Application for a non-material amendment following a grant of planning permission.

Alterations to entrance including new doors window and canopy, erection of a single storey rear extension, path, additional car parking spaces and internal remodeling works to allow the change of use from library storage depot and office to a Register Office for the registration of births, deaths and still-births, dealing with legal preliminaries for ceremonies; conducting ceremonies and associated functions.

Reference number:	<input type="text" value="CCC/20/020/FMW"/>
-------------------	---

Scale	@A1	Date	02.02.2021	Drawn	KJR
1 : 50					
Drawing Title				Checked	SD
GA Roof Plan- Sheet 1 of 2				Revision	P4
Drawing Number					
J4523-YMD-01-RF-DR-A-2207

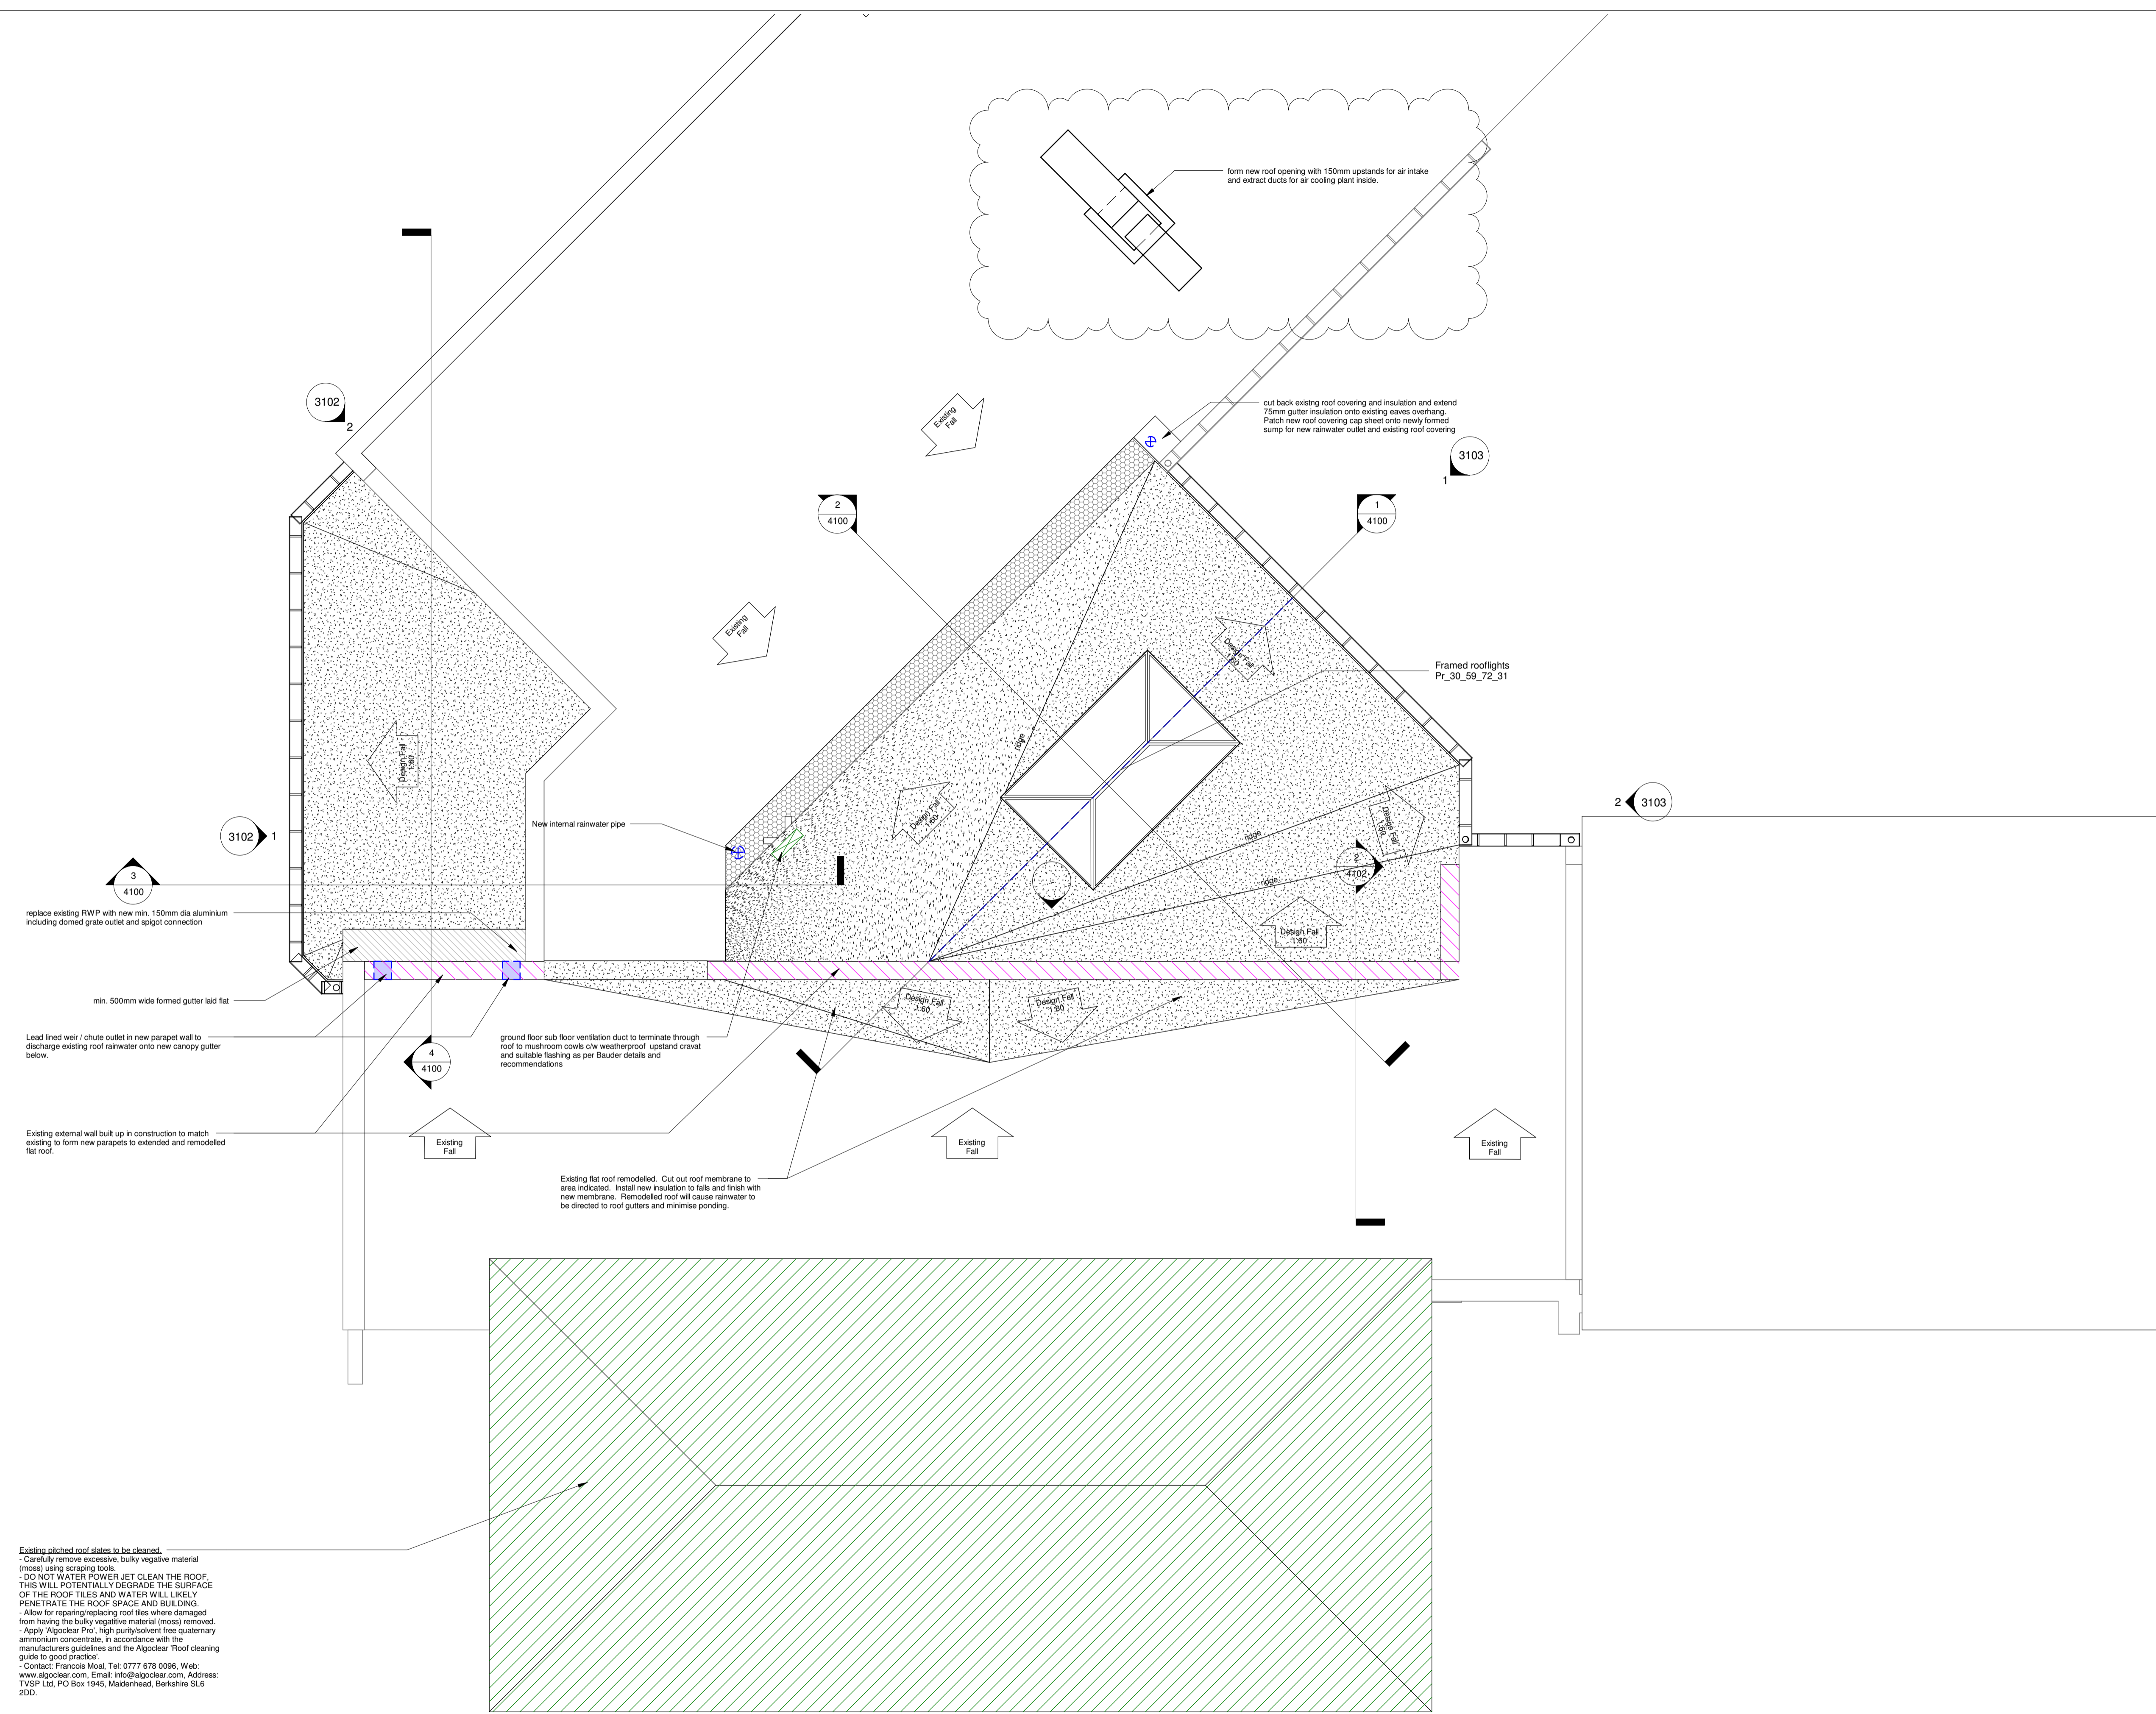
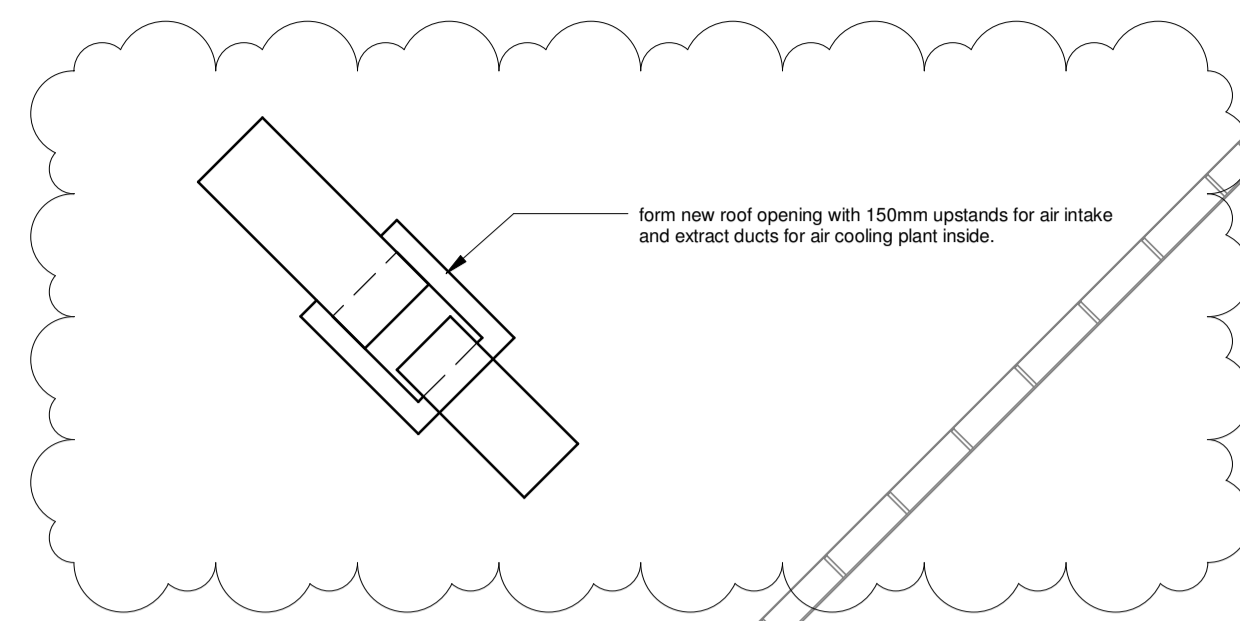
6. New Entrance Canopy; To have no external columns, canopy to be supported off existing external walls.
7. Ceremony Waiting/Ceremony Room; Layout changed in response to alternative egress, i.e. no longer via the rear garden.

10. Roof ducting; Required intake and extract ducts on roof of Ceremony Room/Ceremony Waiting block.

6. New Entrance Canopy; To have no external columns, to provide clear access to main entrance.
7. Ceremony Waiting/Ceremony Room; Layout changed in response to alternative egress, i.e. no longer via the rear garden.

10. Roof ducting; Roof ducts required to supply fresh air and extract to air conditioning units servicing the Ceremony Room/ Ceremony Waiting rooms. Air conditioning essential for these rooms to ensure that windows are not opened in these rooms when being used for ceremonies, to ensure proposals compliant with planning requirements.

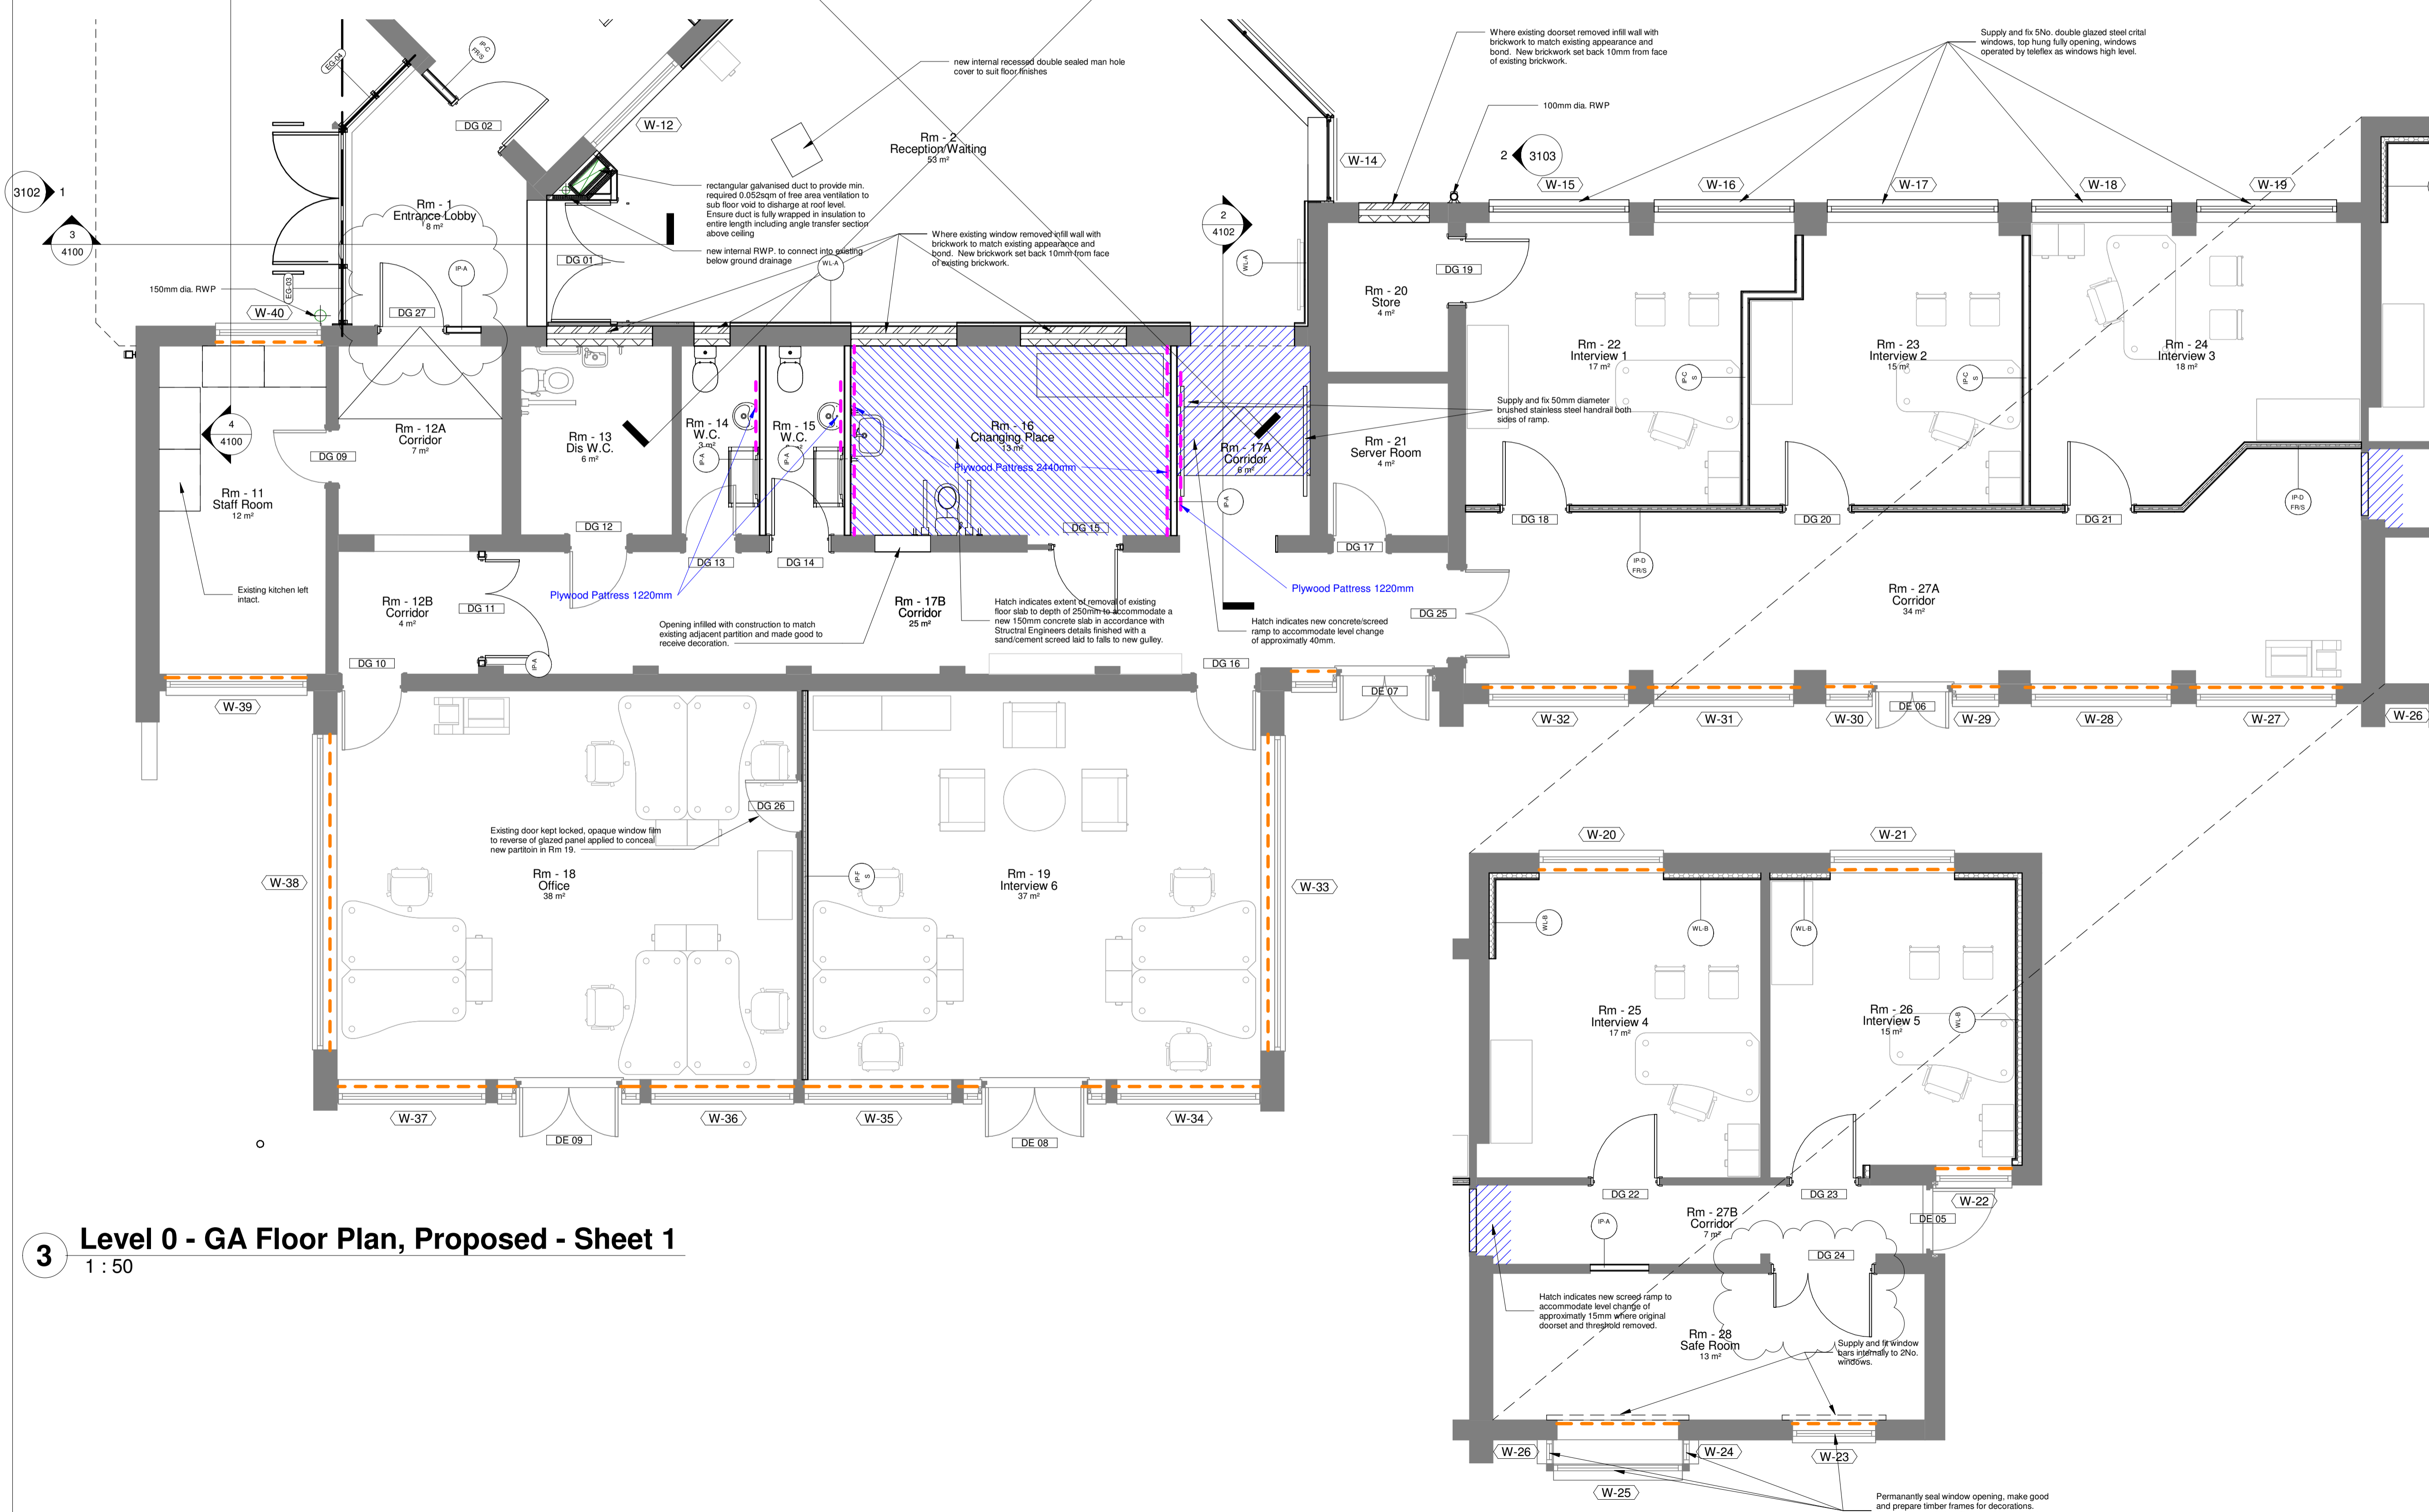
1. Photographic Area; Paving clarified. Proposed Pagoda changed to a timber Pergola. External plant area revised to accommodate required plant.
2. External exit from ceremony room; Rationalised to ensure proposals work with existing structure. Ramped egress with handrail proposed to provide level access from ceremony room.

5. Windows; Secure Store Room/Safe Room 28 windows left intact, windows to be secured with internal railings not shutters. Plant Room 4 external doors updated and external wall infill proposal changed to with existing structure. New windows/doors proposed to Entrance Lobby and Reception/Waiting 2. New high level metal framed windows proposed to be installed to Interview 1, Interview 2 & Interview 3. All other existing windows to be retained and secondary glazing installed. Windows to toilets 13, 14, 15 & 16 which are internalised by new rear extension removed and openings infilled to provide adequate acoustic privacy to toilets.

8. Internal doors; Additional internal door DG27 and associated partition proposed between Corridor and Entrance Lobby to provide security to staff areas from public. Additional internal door DG01 and associated partition proposed between Reception/Waiting and Entrance Lobby to provide draught lobby at main entrance doors. Interview 4 & Interview 5 doors replaced with larger doors to improve access to room for wheelchair users and visitors with pram's/buggy's. Secure Store Room/Safe Room 28 replacement door 1.5 leave's so room accessible for safe delivery and removal.

9. Internal partitions; Partition proposed between Interview 1 & Interview 2 realigned so buildable and window W-16 accessible. New partition proposed to be installed between Room 18 & 19, adjacent existing timber partition to be left intact to provide acoustic privacy between Interview room 6 and Office 18.

1. Photographic Area; To provide functioning space for required outdoor plant. Pergola more practical and in keeping with area than Pergoda.
2. External exit from ceremony room; To provide DDA compliant egress. External door arrangement revised to ensure existing elevation structure not undermined.

5. Windows; Secure internal railings proposed in lieu of shutters in safe room to provide free flow of air and avoid potential for condensation with potential to damage windows. Existing windows replaced or to have secondary glazing to improve thermal performance of building.

8. Internal doors; Additional internal door DG27 and associated partition proposed between Corridor and Entrance Lobby to provide security to staff areas from public. Additional internal door DG01 and associated partition proposed between Reception/Waiting and Entrance Lobby to provide draught lobby at main entrance doors. Interview 4 & Interview 5 doors replaced with larger doors to improve access to room for wheelchair users and visitors with pram's/buggy's. Secure Store Room/Safe Room 28 replacement door 1.5 leave's so room accessible for safe delivery and removal.

9. Internal partitions; Partition proposed between Interview 1 & Interview 2 realigned so buildable and window W-16 accessible. New partition proposed to be installed between Room 18 & 19, adjacent existing timber partition to be left intact to provide acoustic privacy between Interview room 6 and Office 18.
